Householder Proforma

Application Ref: 2021/0889
Address: 14 Lund Crescent, Lundwood, Barnsley, S71 5LQ
Neighbour Representations: No
Consultations No
Property Description: the property is located in a purely residential area of similar styled dwellings. The property in question is located in a unique position within its attached neighbour. The attached property is located up to the back edge of the pavement at a bend in the road with the properties to the east of the application dwelling being located at 90 degrees to it.
The two storey, pitched roof dwelling is constructed from buff brick with brown concrete roof tiles.
Proposed Extension: erection of a first floor side extension above existing single storey side extension
UDP Designation: Housing Policy Area
Local Plan Designation: Urban Fabric
Conservation Area: No
Relevant History: N/A
Acceptable in Principle: Yes

DRAWING STAGE:
PLANNING
DRAWING TITLE:
PROPOSED BUILDING PLANS

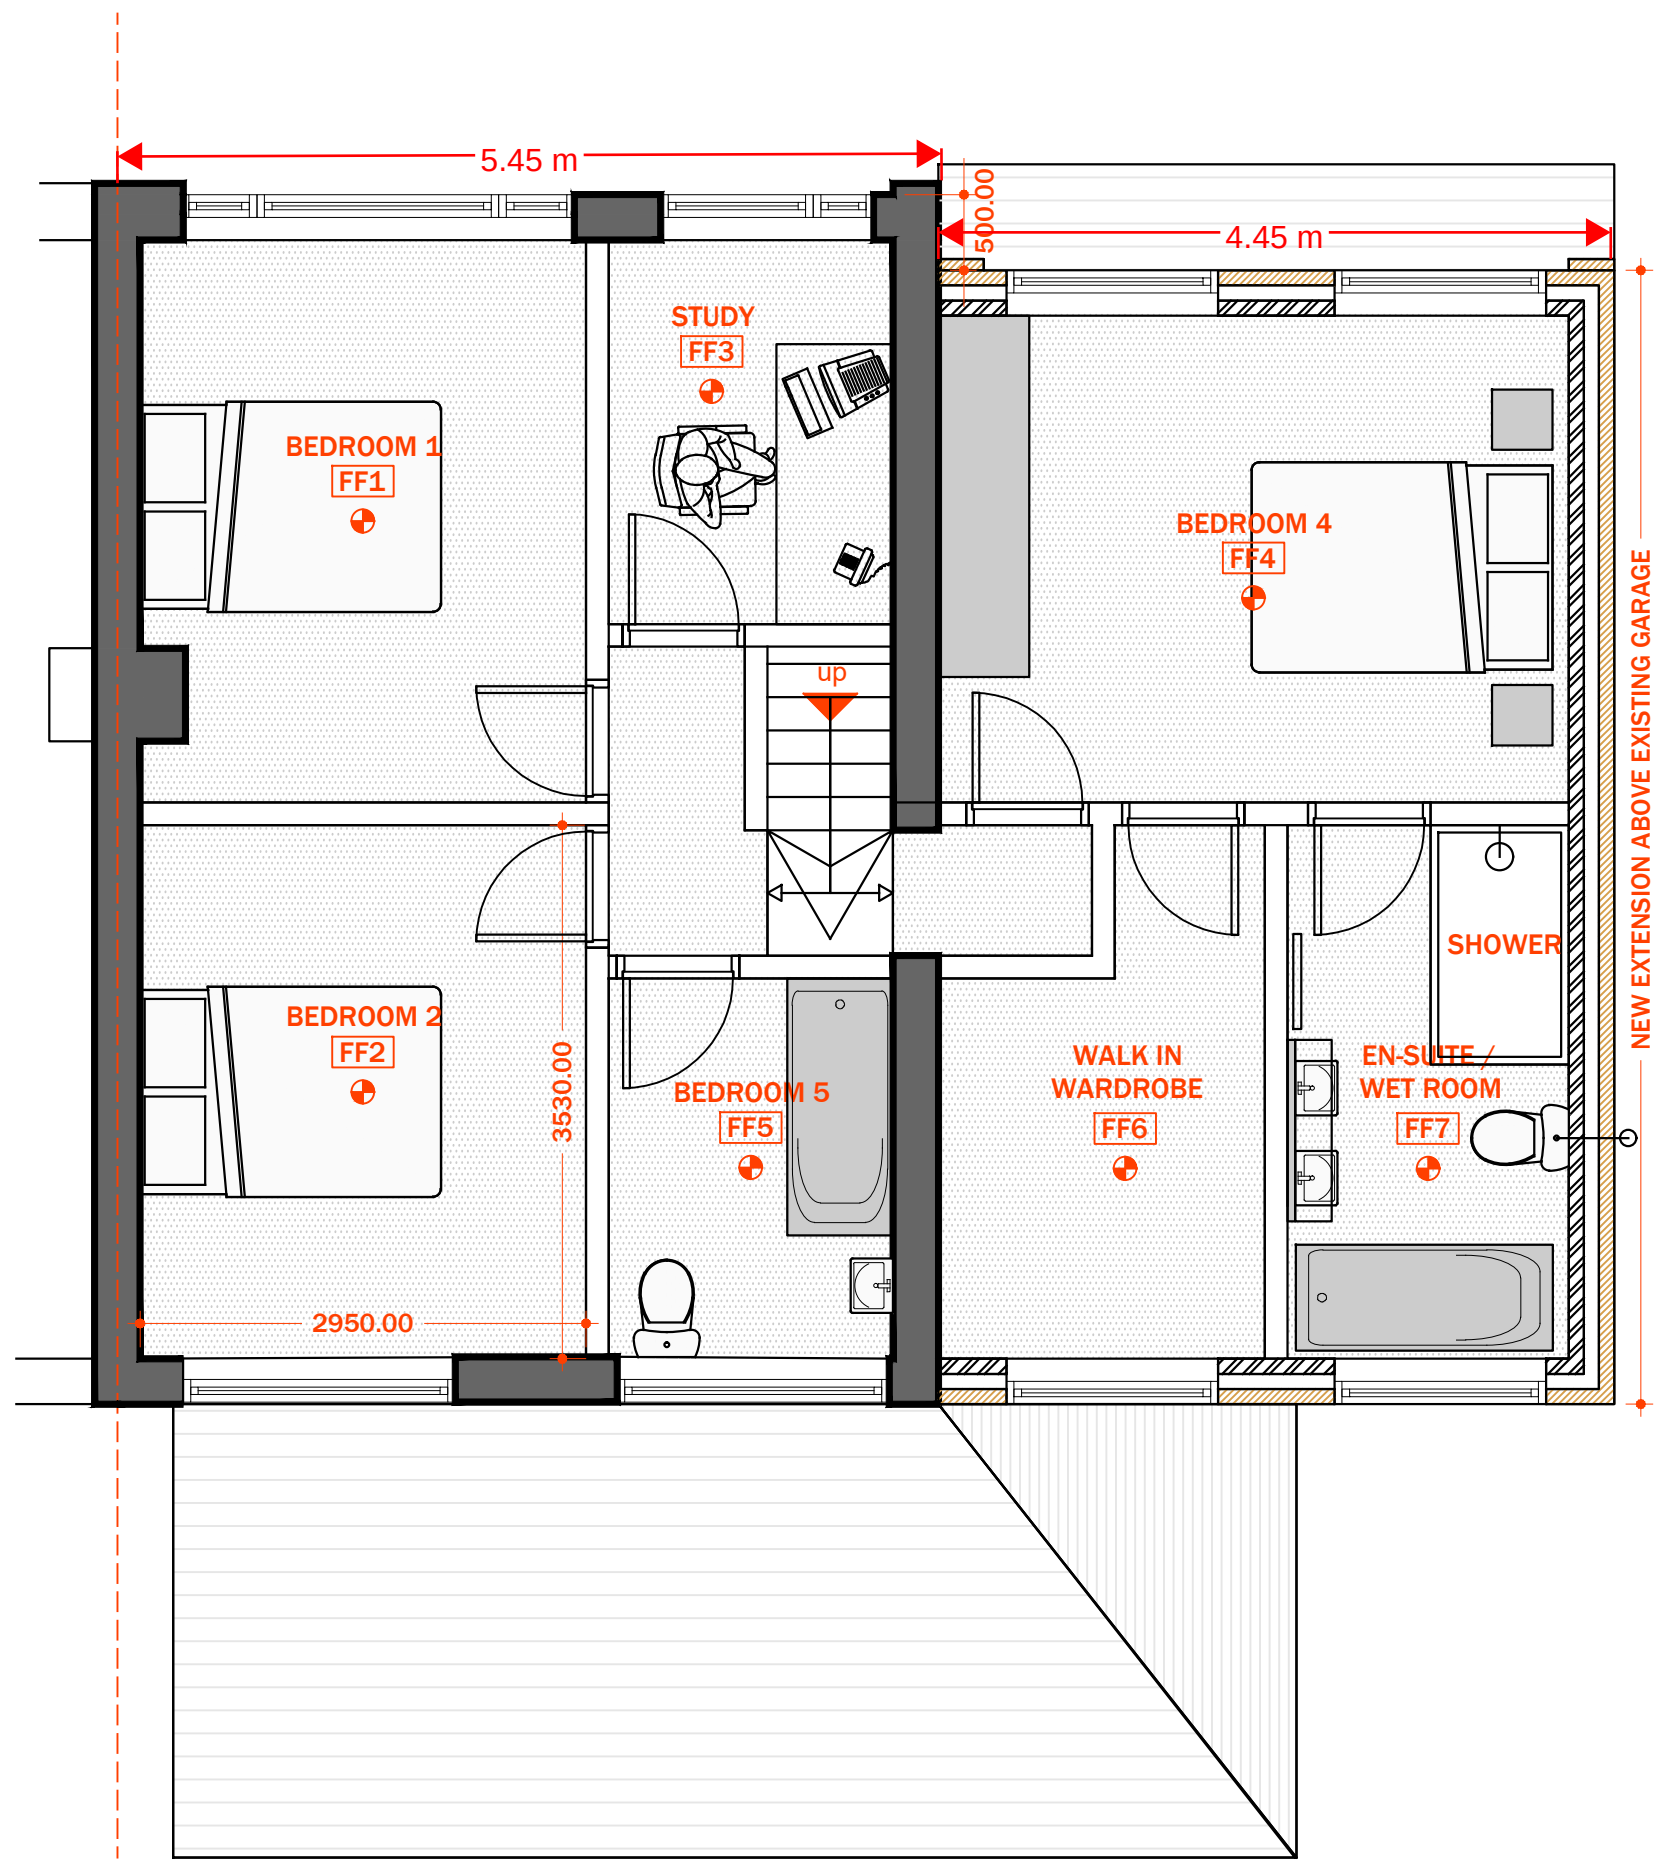
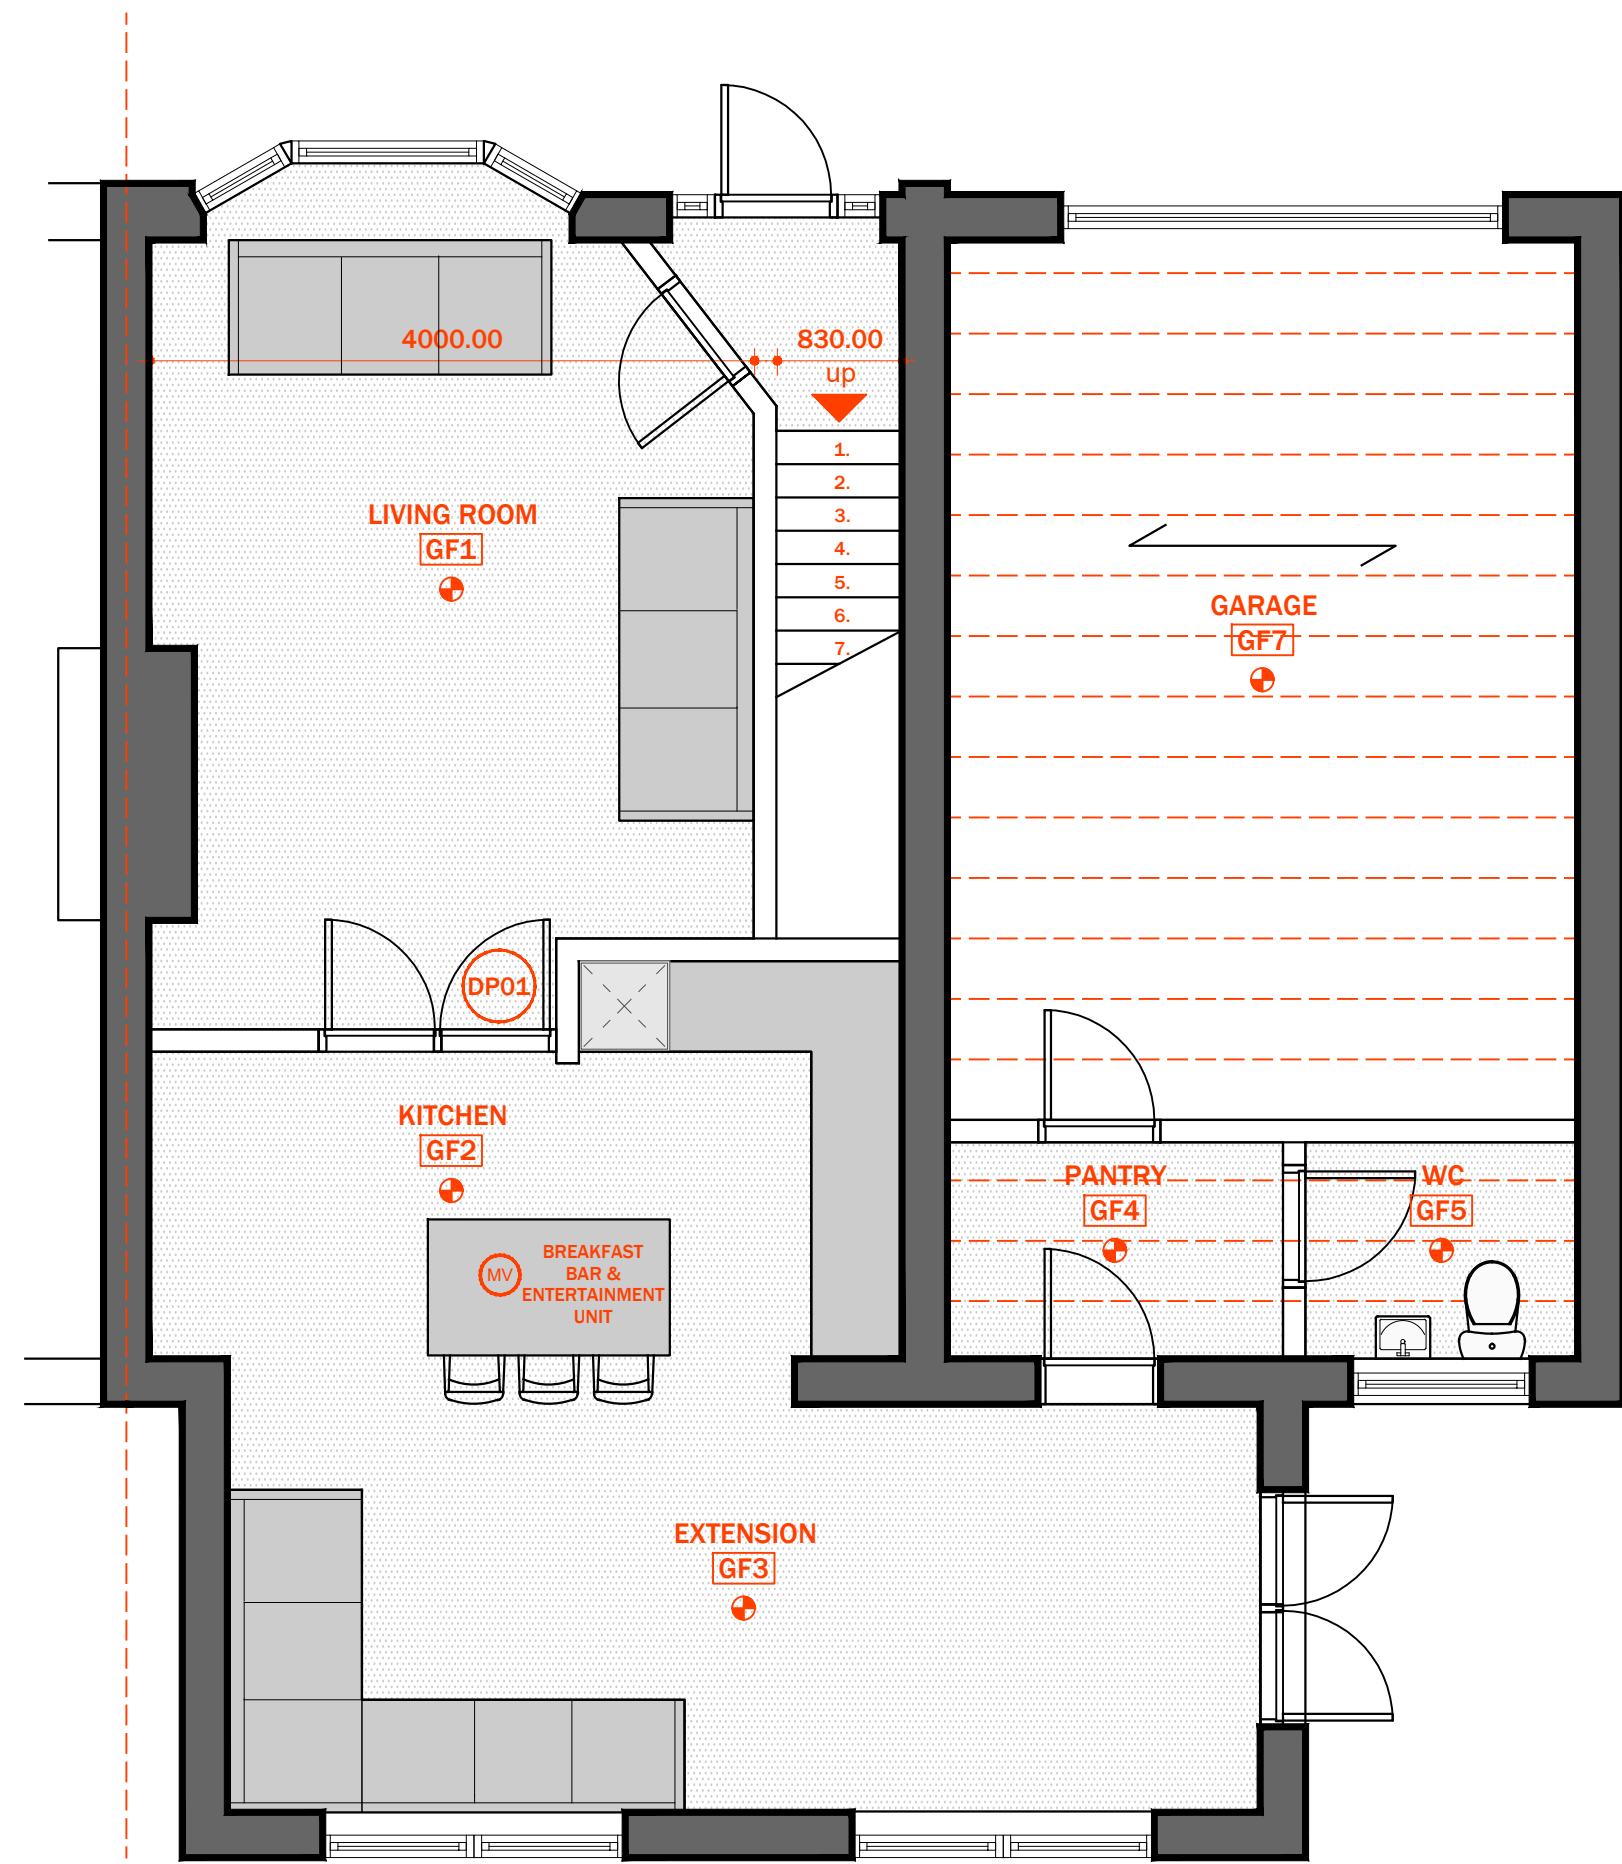
The proposal has been amended during the application process which includes the set back at first floor level.

Yes / No (include comment if required)
Single Storey	
1. set back	
Two Storey / First Floor	
2. set back / set down (500mm minimum)	Yes: 500mm
3. less than 2/3 the width of the original dwelling	No. proposed dwelling 5.5m - proposed first floor side extension 4.4m. Under SPD 2/3 width of dwelling is allowed, in this case 3.6m. Given that the extension is located above an existing single storey side extension the width cannot be reduced to comply with the policy without looking contrived. The pair of dwellings are located in isolation within the street scene, with an extensive gap between the side elevation of the dwelling as extended and the rear elevation of the neighbouring property and the original dwelling remaining the dominant feature with the inclusion of the set back of 500mm at first floor level. Therefore the increase of 0.8m above the allowances set out in the SPD is considered acceptable in this instance.
